FAO: Planning Department,  
Welwyn Hatfield Borough Council

Ref: 6/2021/1062/LB & 6/2021/1061/HOUSE  
Date: 09/06/2021

## HISTORIC BUILDINGS AND CONSERVATION ADVICE

**RE: 24 Church Street, Hatfield, AL9 5AW**

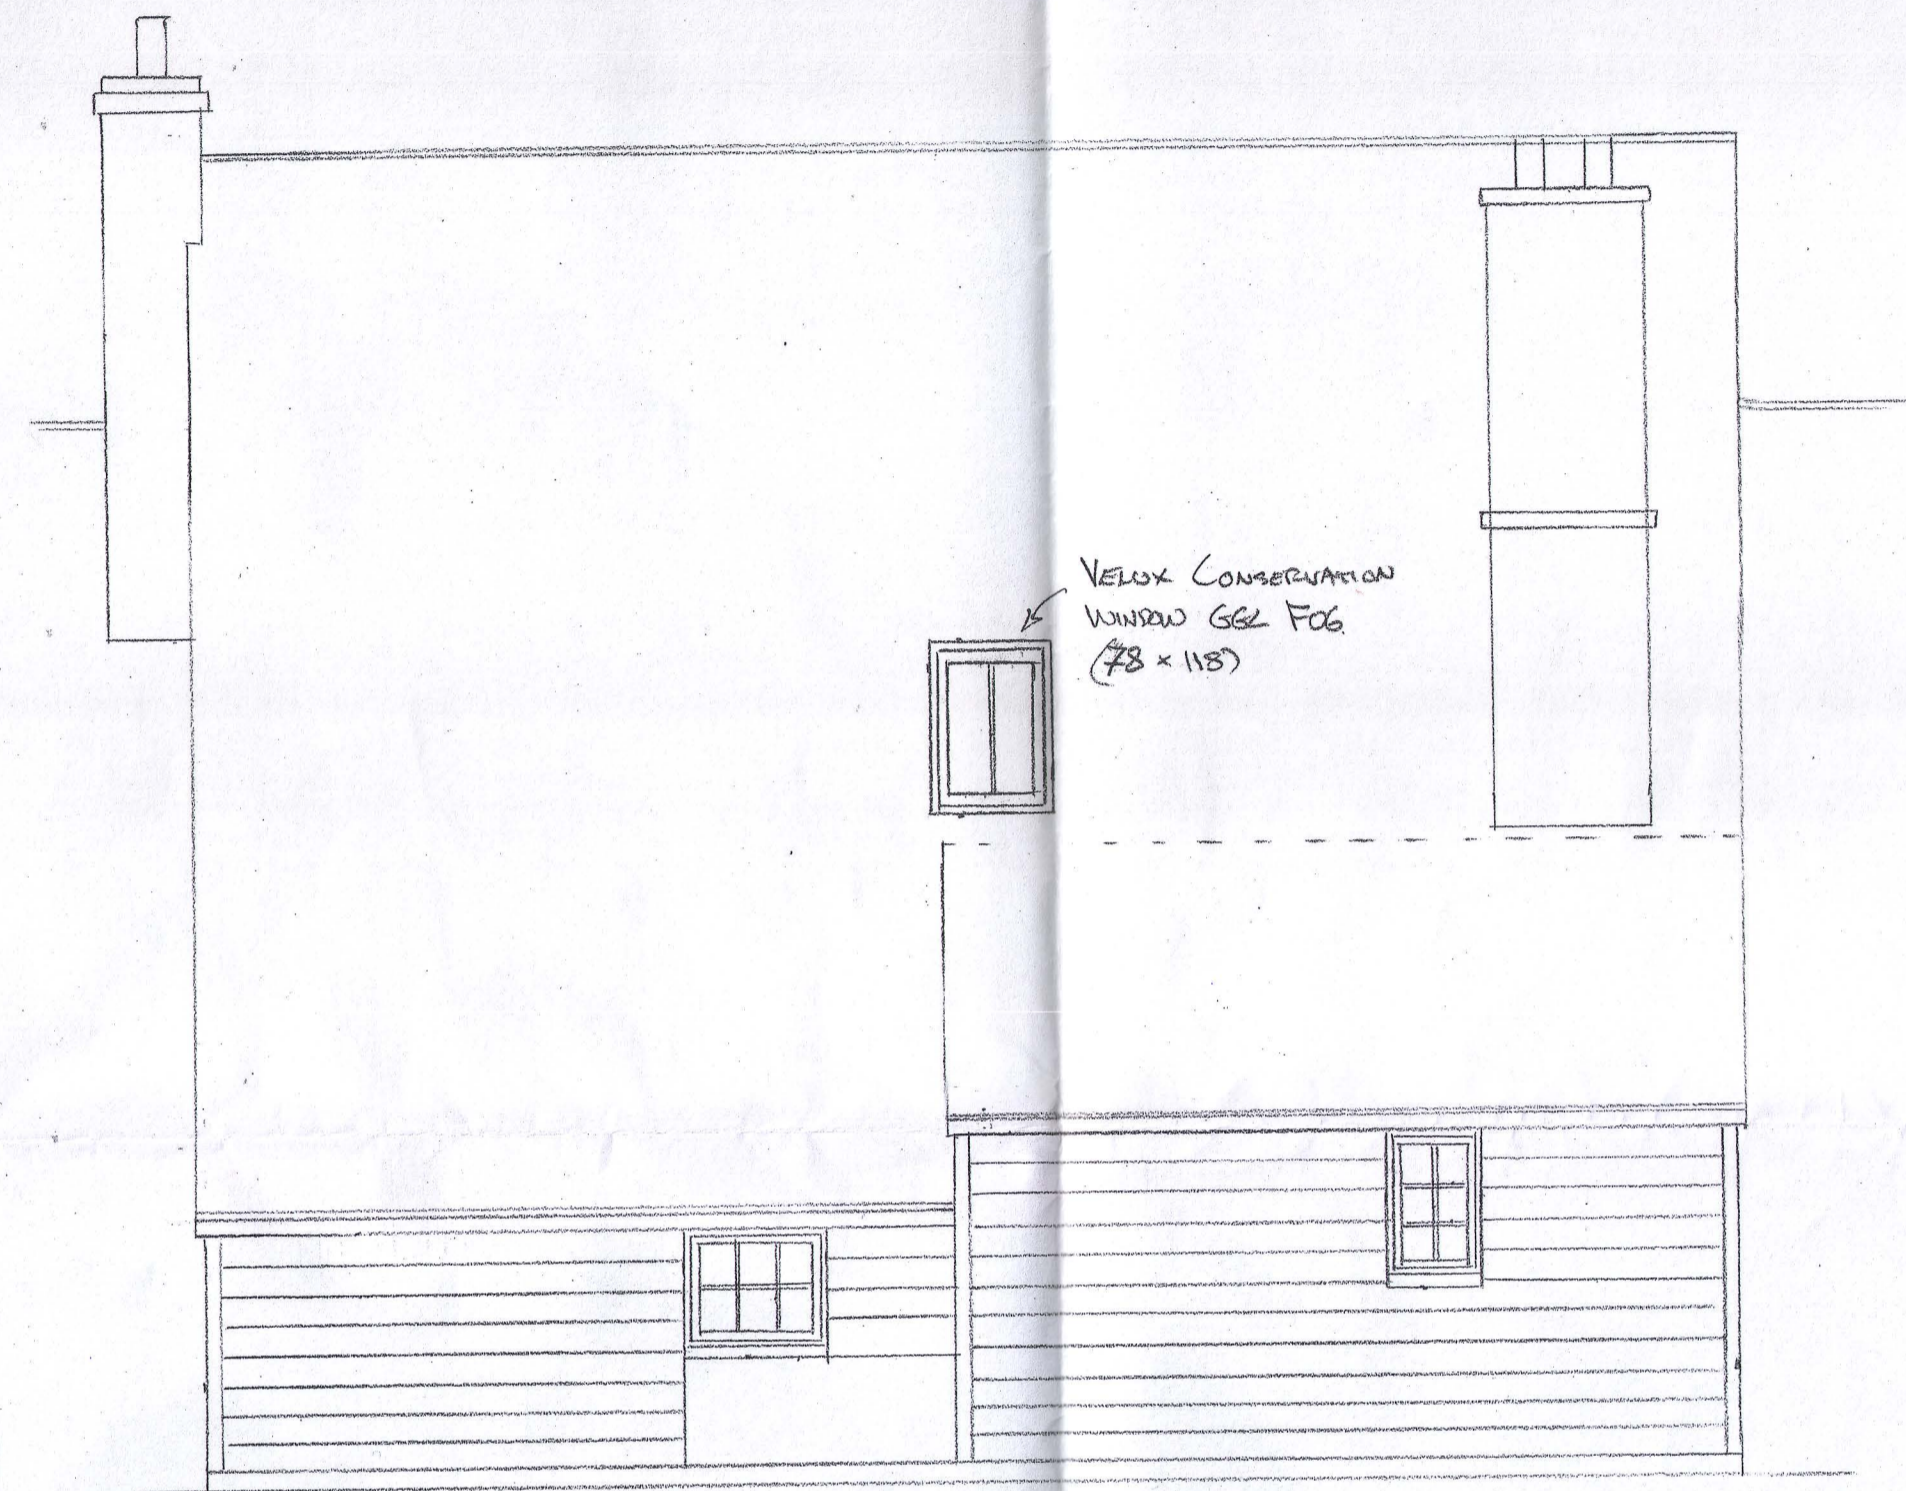
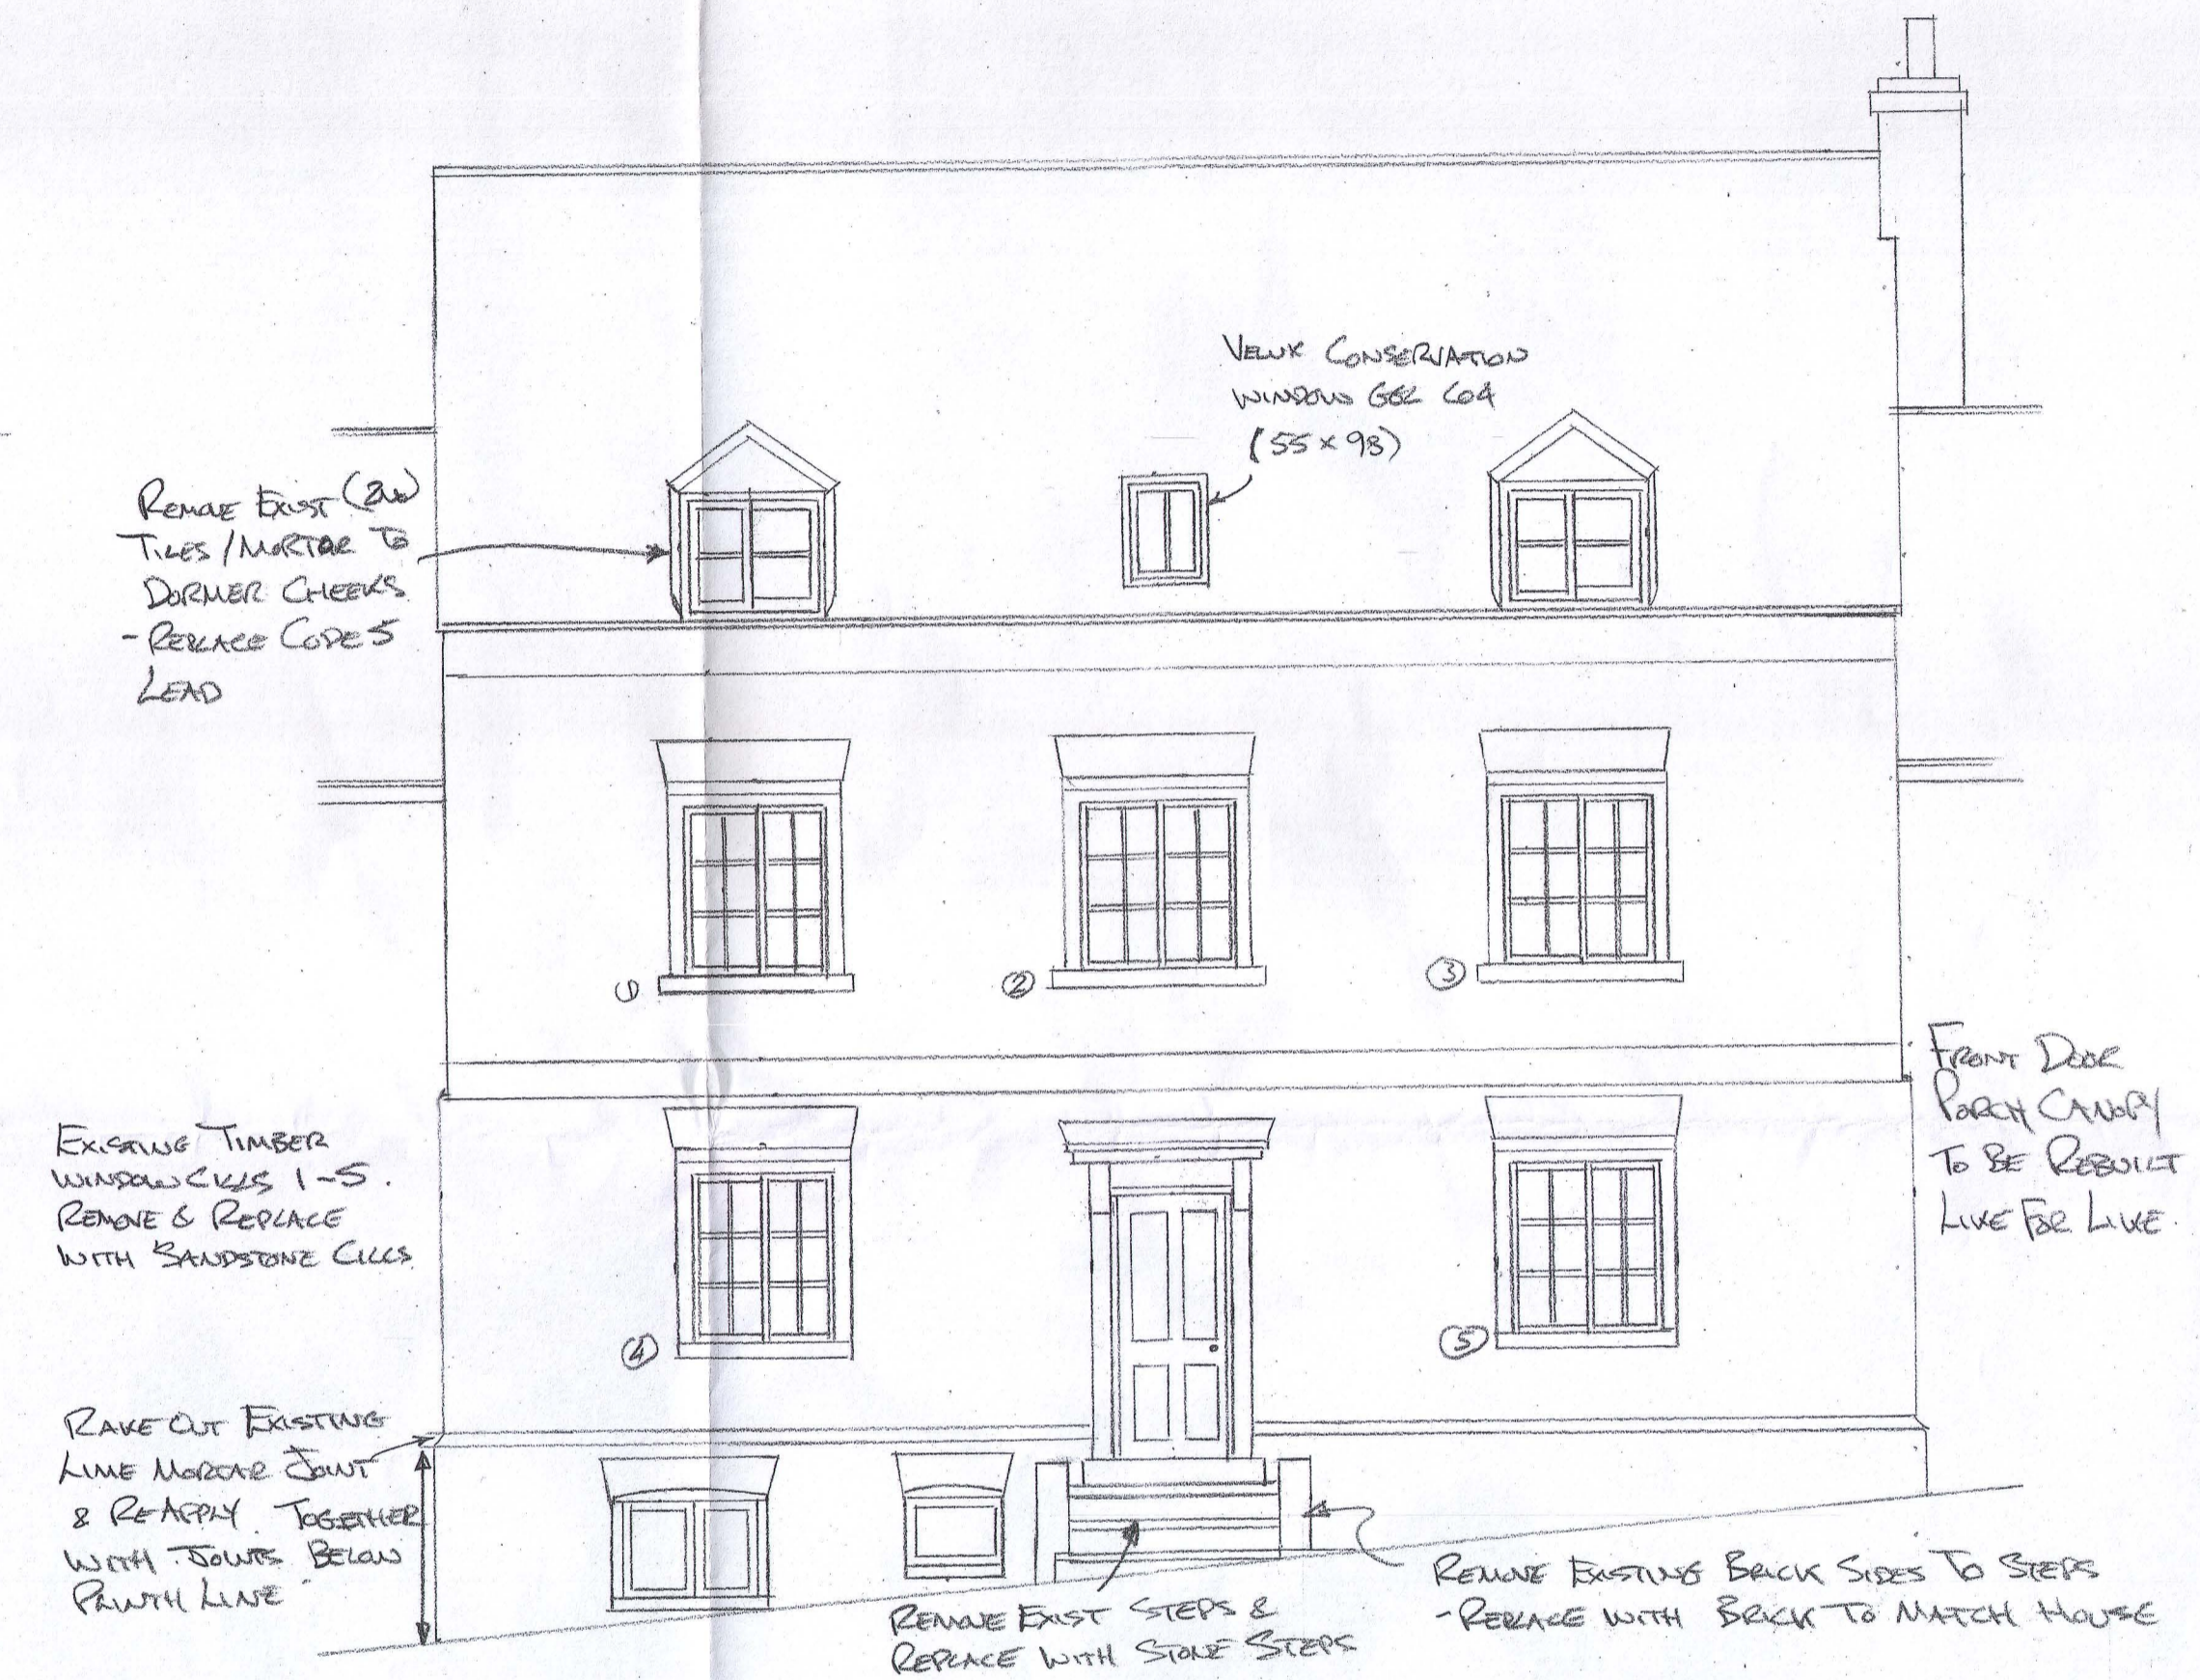
The proposals have been revised to omit the front rooflight (better preserving the traditional appearance of the front roofslope) and to replace the cills with timber rather than stone (timber being a more in keeping with the local vernacular). It has also been confirmed that the rear rooflight will be positioned between existing rafters to avoid the unnecessary loss of historic fabric.

- The rooflight positioned to be flush with the roof tiles;
- Samples (including photographs) and details of stone and brick for steps; and
- Sample panel of repointing to show mortar colour and mix, and pointing profile.
